## Department of Planning and Environment

Our ref: DOC22/226997

Your Ref: SSD-29999239

### Subject: Request for Advice: Rooty Hill Materials Recycling Facility (SSD-29999239)

Figure 8. Vegetation zones

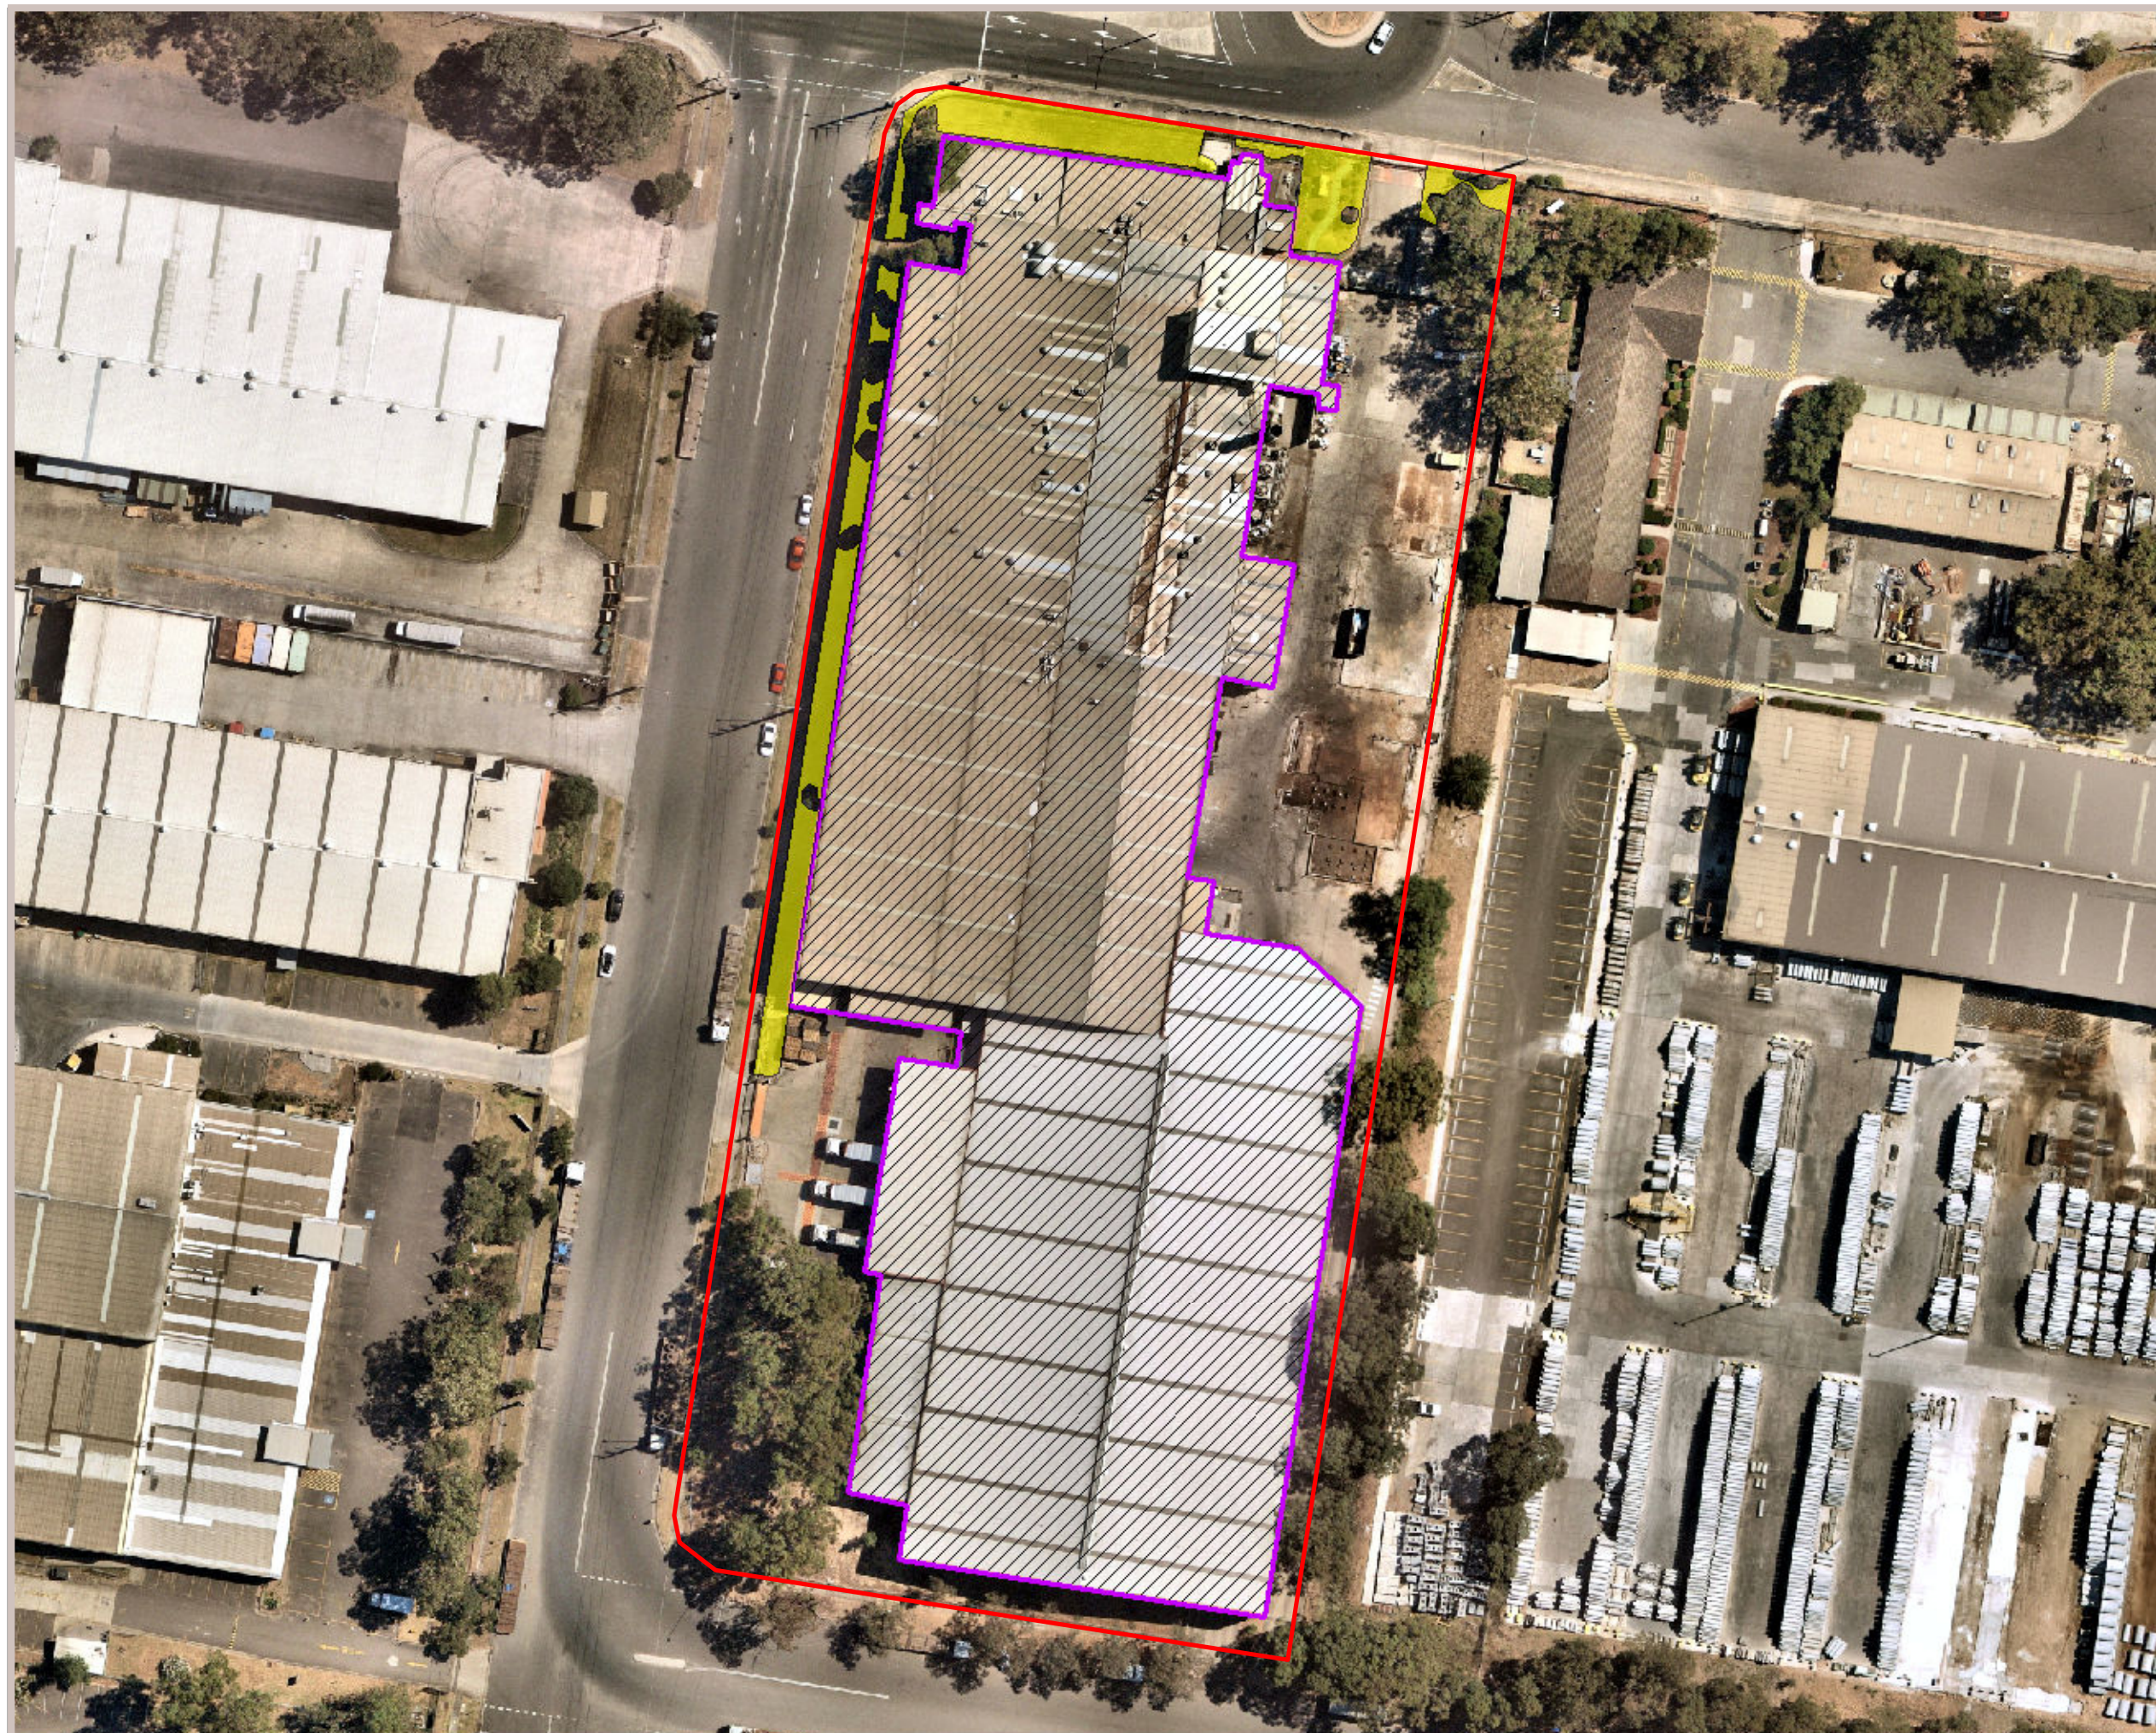
The correct maps have been provided in accordance with the BAM, however, EHG is concerned the proposed cut and fill will impact the root systems of the trees on adjoining land and therefore the losses will be greater than the impacts that have been estimated on the subject land.

An arborist will need to inform what the level of impacts will be. Given the potential impact on neighbouring trees, tree protection measures should form part of the avoid and minimise measures.

- Small areas of Cumberland Plain Woodland, which is at risk of serious and irreversible impacts (SAIL), have been identified on the subject land. Given the limited extent of impacts and the industrial nature of the local area, the impact is not likely to constitute SAIL. However, vegetation mapping and the extent of impacts needs to be updated in accordance with impacts from cut and fill to TPZs of trees to be removed in accordance with the *Arboricultural Impact Assessment*.
